# DECISION DELEGATED TO HEAD OF PLANNING

<b>Application No:</b>	<b>H22-0709-25</b>	<b>Applicant:</b>	<b>Sennen Homes Limited</b>
<b>Proposal:</b>	Erection of 2 detached bungalows - Approved under H22-0280-24. Amendment to Plot 8 to reduce width & depth of bungalow, opening sizes to bed 1 & living room amended & wc window removed		
<b>Location:</b>	Former 87 Moulton Chapel Road Cowbit Spalding		
<b>Terminal Date:</b>	21st August 2025

TITLE
PROPOSED SITE LAYOUT
WITH SURFACE WATER DRAINAGE ROUTE

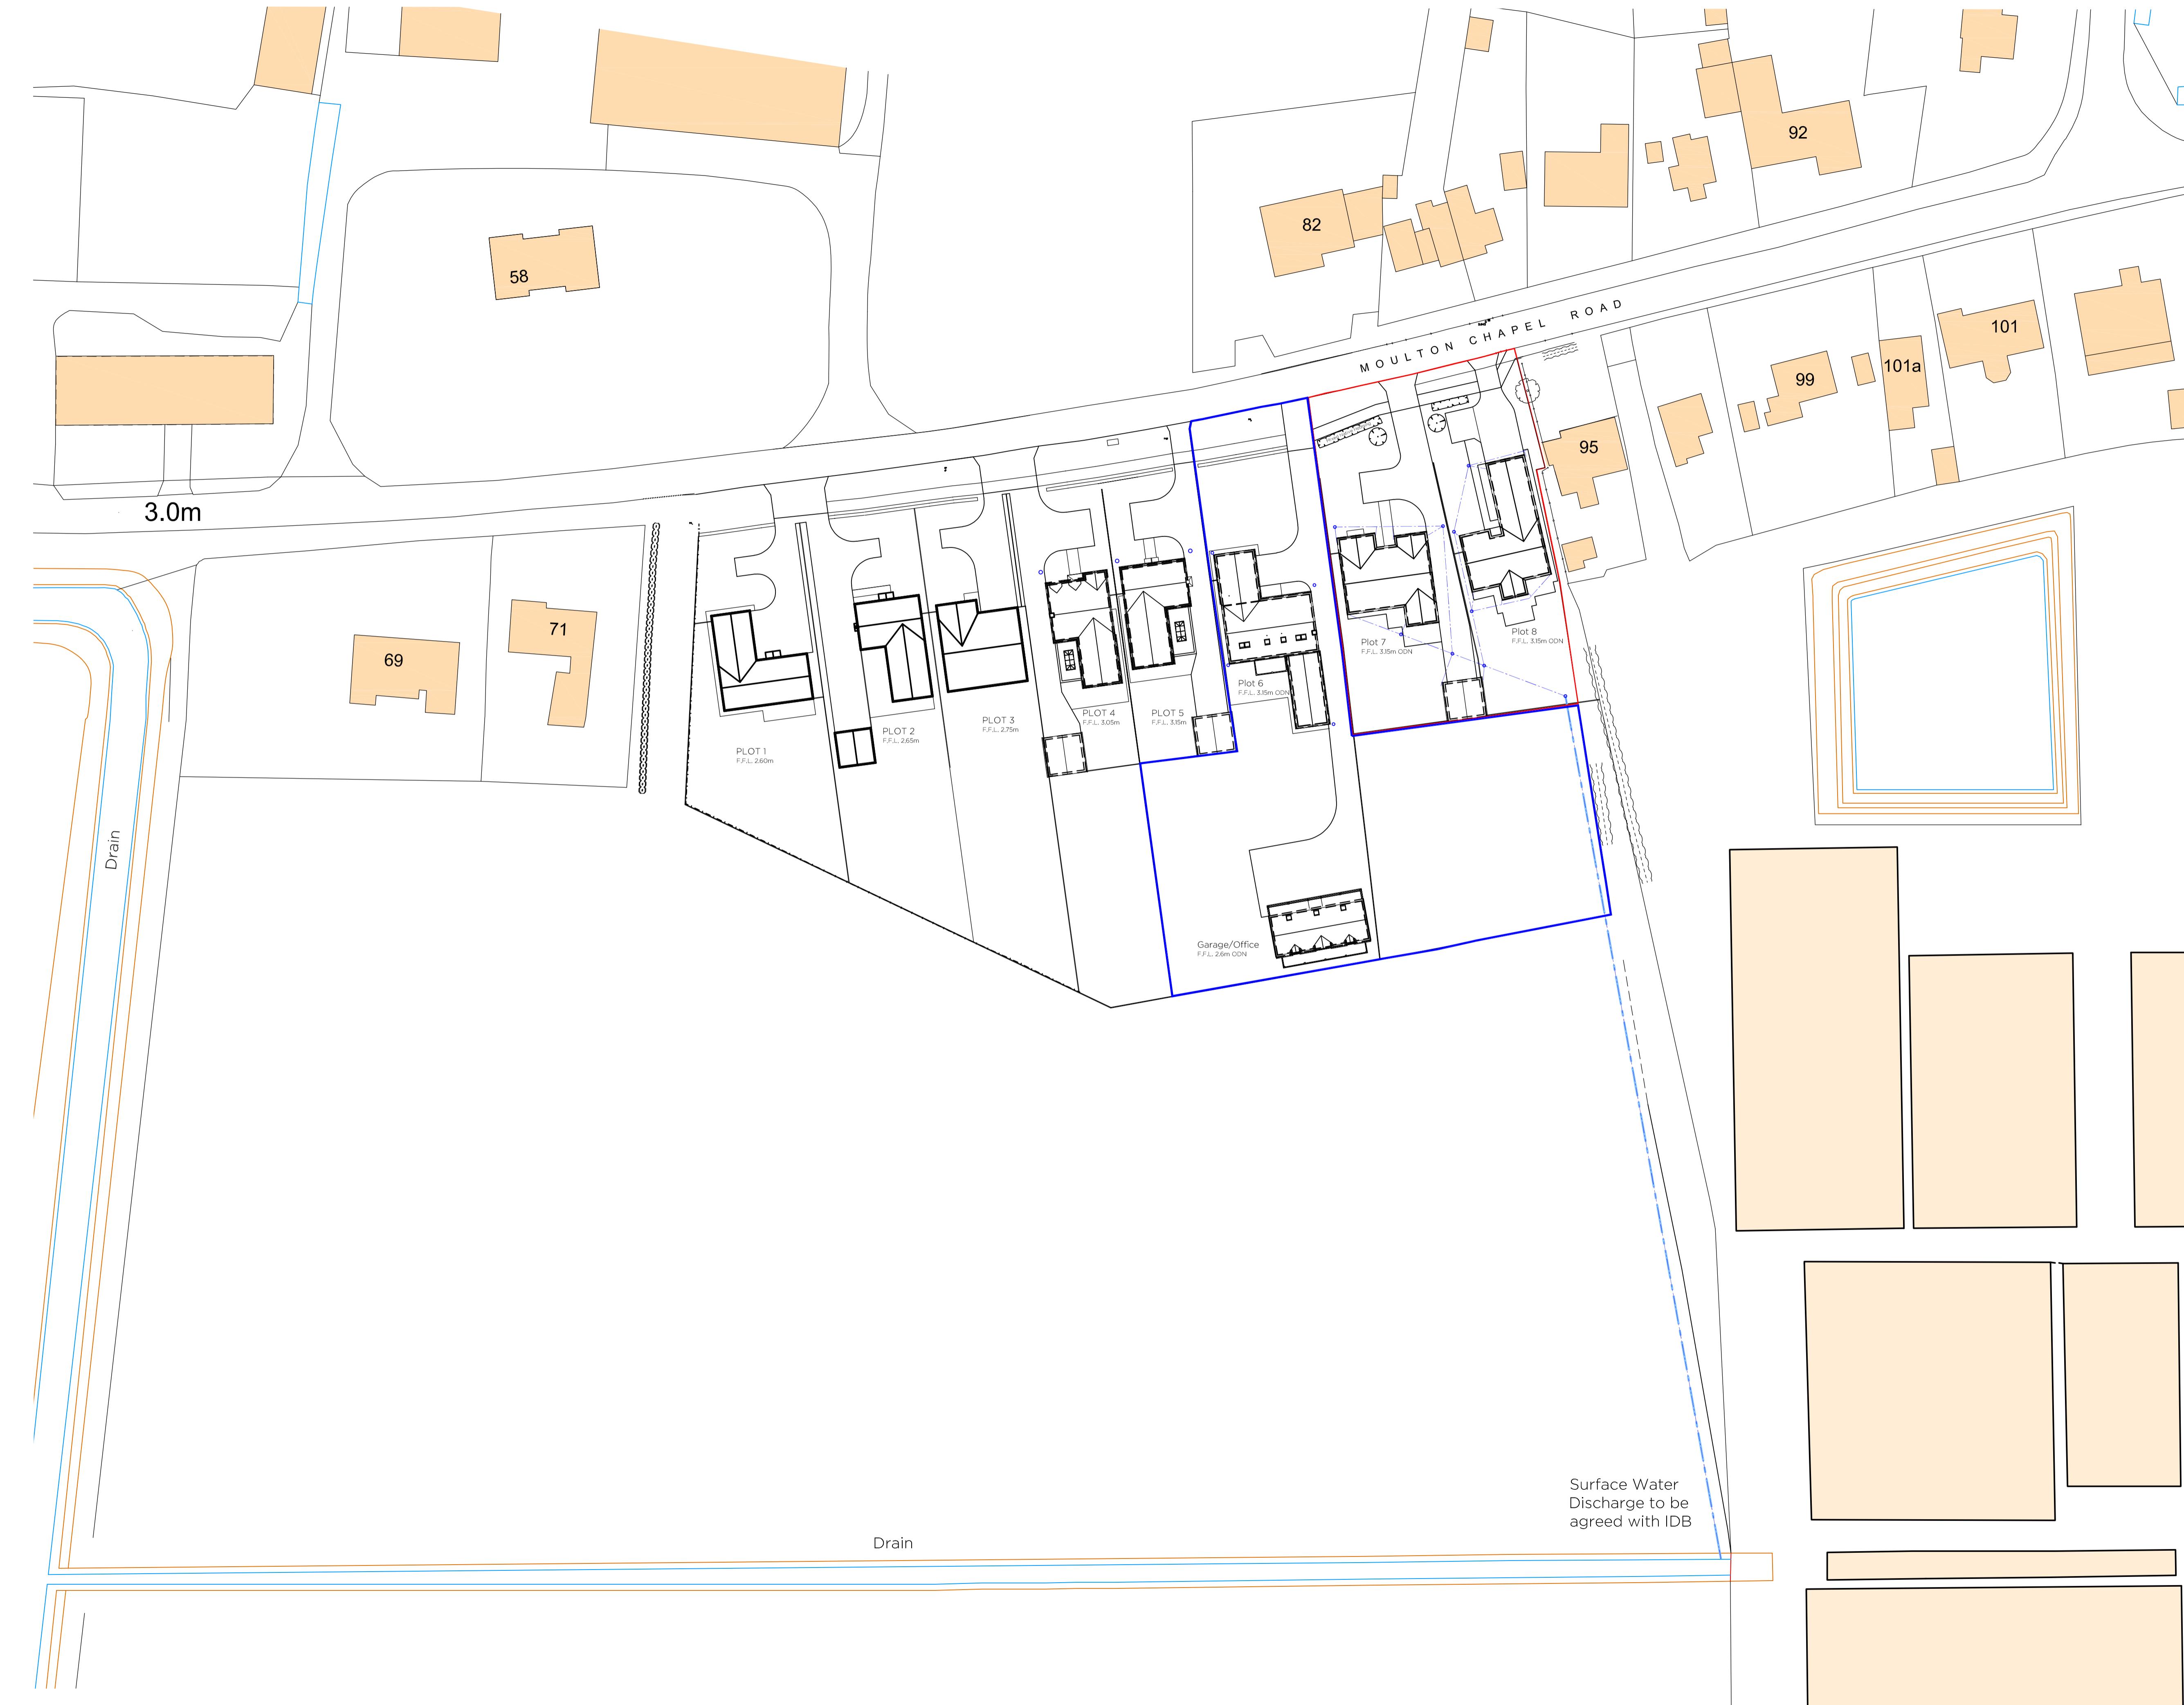
Condition 4 of permission H22-0280-24 requires the ground levels and finished floor levels of the development to be carried out in accordance with the previously approved site layout (047 P01 Rev A). Furthermore, condition 5 of permission H22-0280-24 requires the installation of a 2m high fence

to be erected along the eastern boundary of the site indicated by a solid yellow line on the previously approved site layout (047 P01 Rev A). The levels remain unchanged within the amended site layout plan (047 P01 Rev B). Furthermore, the yellow line remains unchanged. Therefore, it is not considered necessary to update these conditions.

TITLE
PROPOSED PLANS & ELEVATIONS - PLOT 8

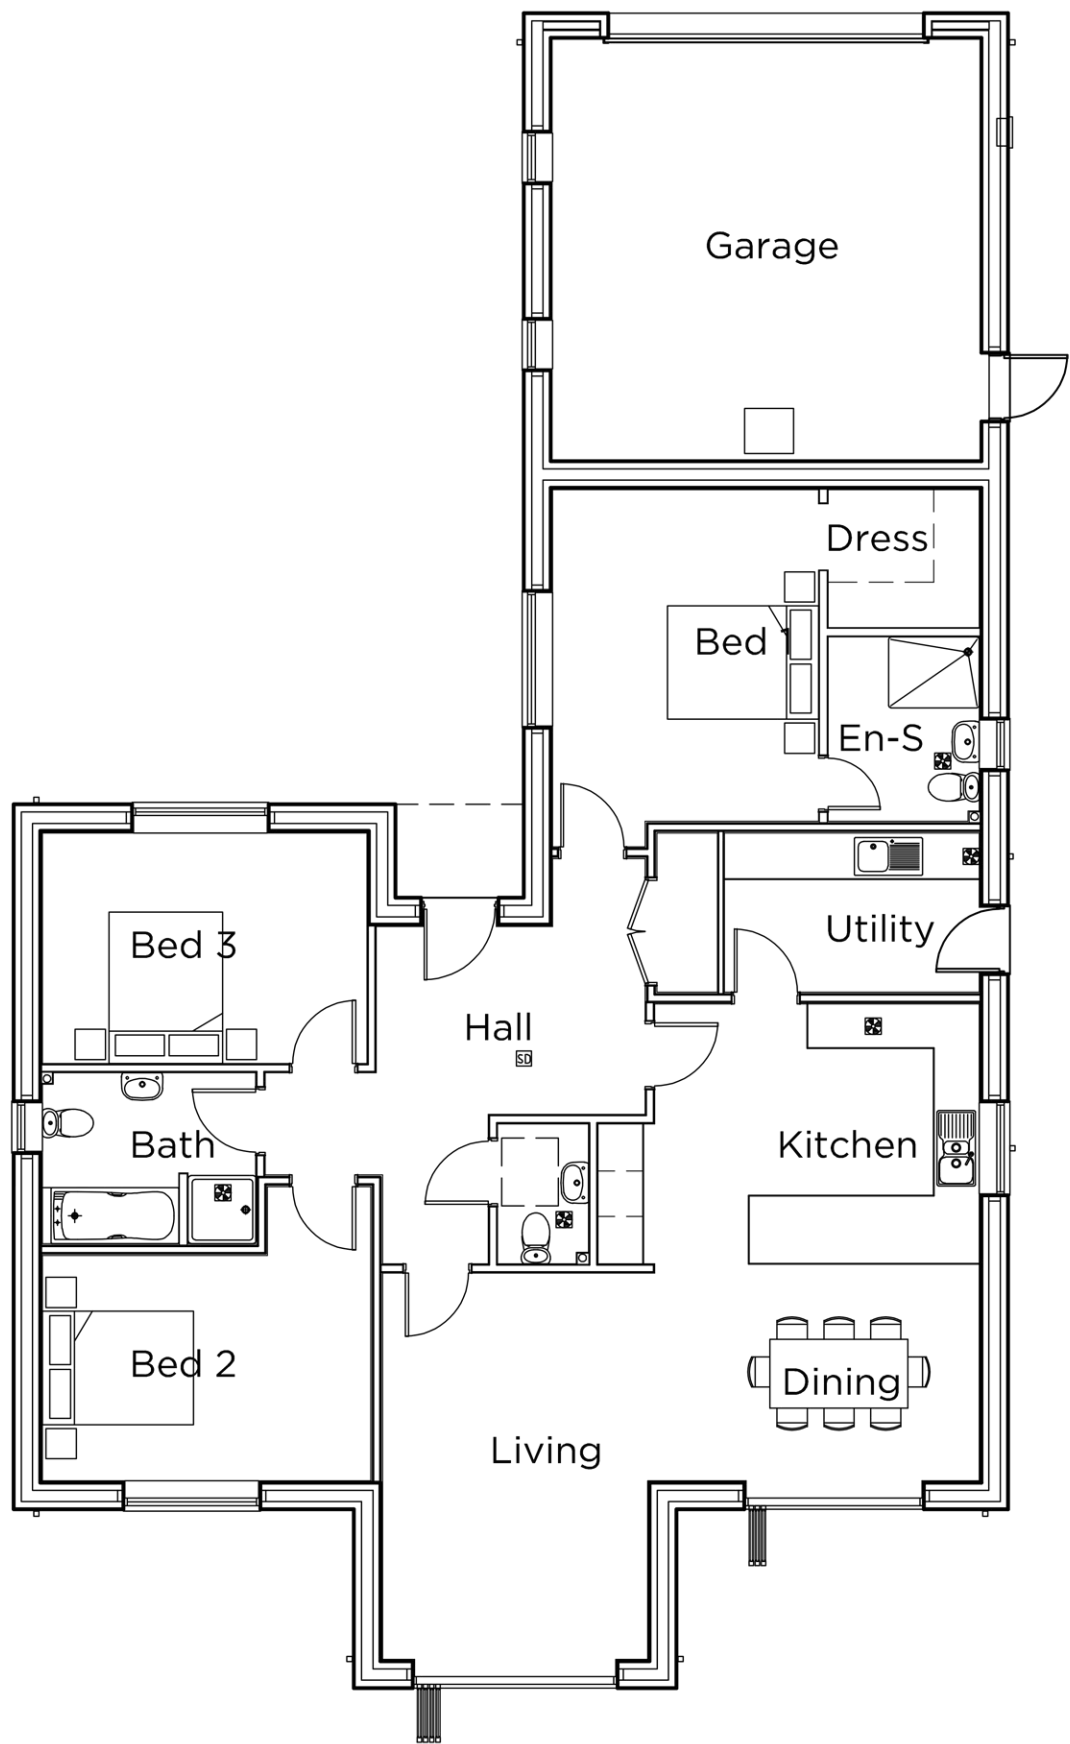
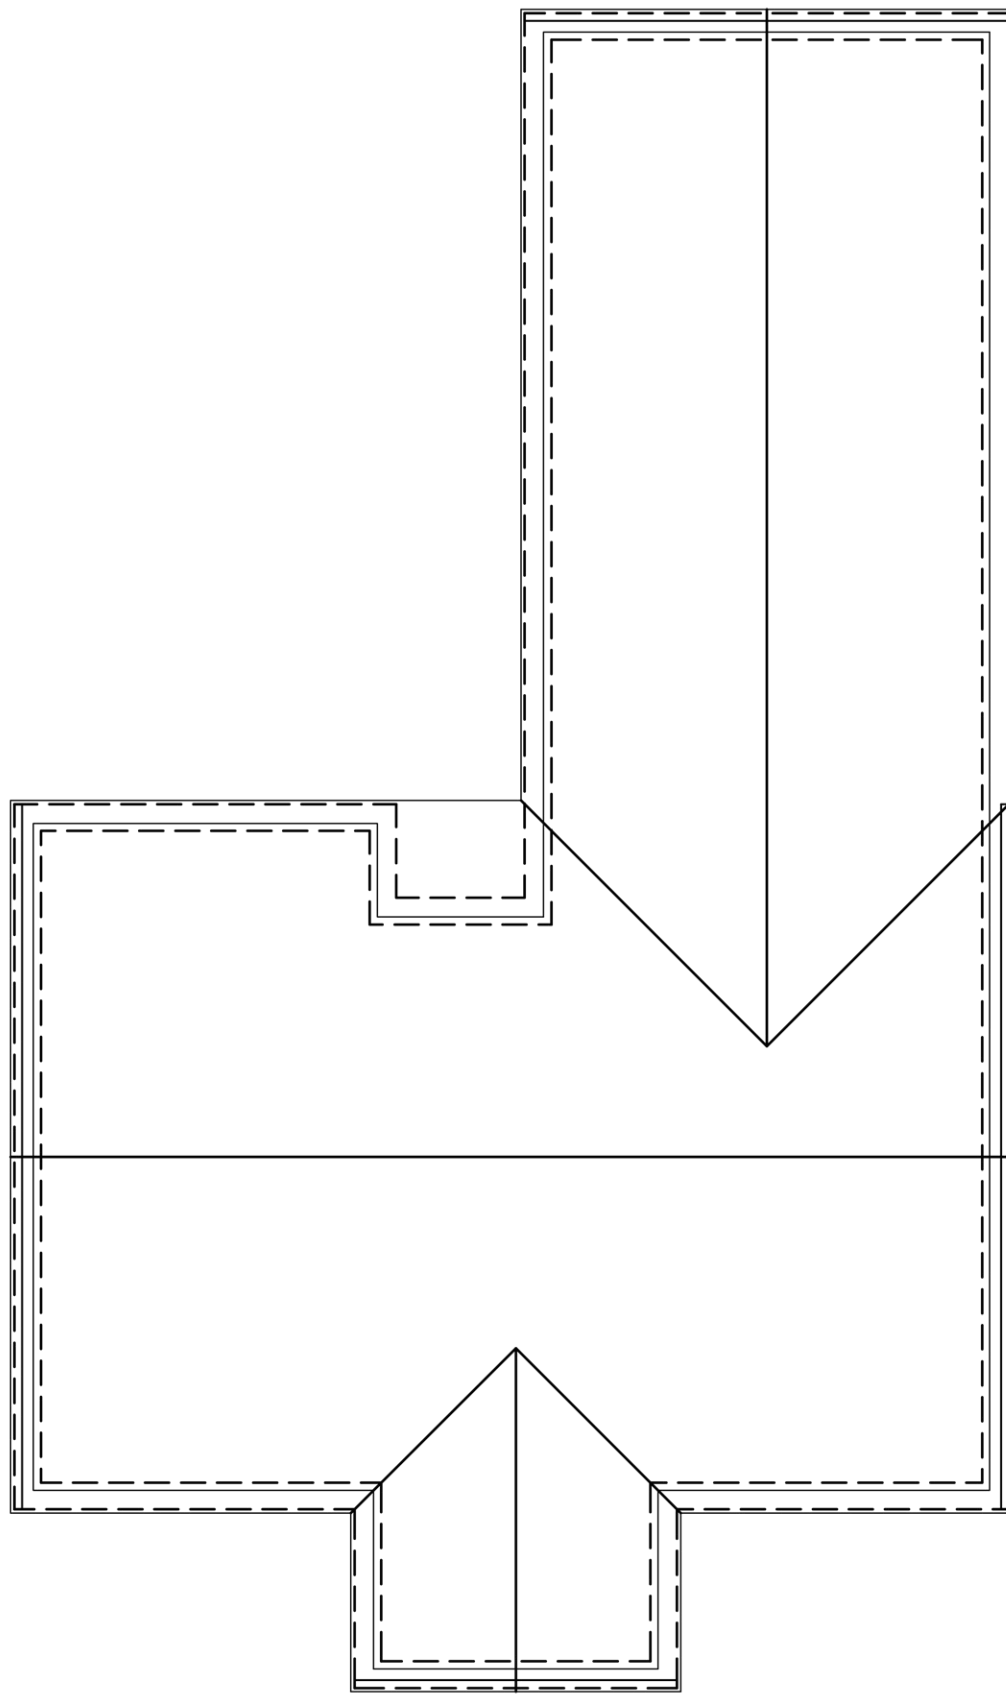
The current proposal seeks to reduce the width and depth of Plot 8. Previously the maximum width of the dwelling was 13.7m and the maximum length was 23.5m. Within the amended plans the maximum width is 13.1m and the maximum length is 22m. The reduction is therefore minimal, and this would not have a significant impact on the overall character and appearance of the dwelling.

An additional window is proposed on the eastern elevation of the dwelling. This window would connect to an ensuite bathroom. Condition 5 requires a close boarded fence measuring 2m in height to be installed along the eastern boundary of the site. Therefore, the proposed bathroom window should not result in an unacceptable degree of overlooking with 95 Moulton Chapel Road, which is located to the east of the site.

The window that is connected to bedroom 1 on one of the western elevations is proposed to be slightly larger. The visual impact of this is acceptable.

The window that was proposed next to the front door on one of the northern elevations is proposed to be removed to allow for the width of the dwelling to be reduced. The visual impact of this is acceptable.
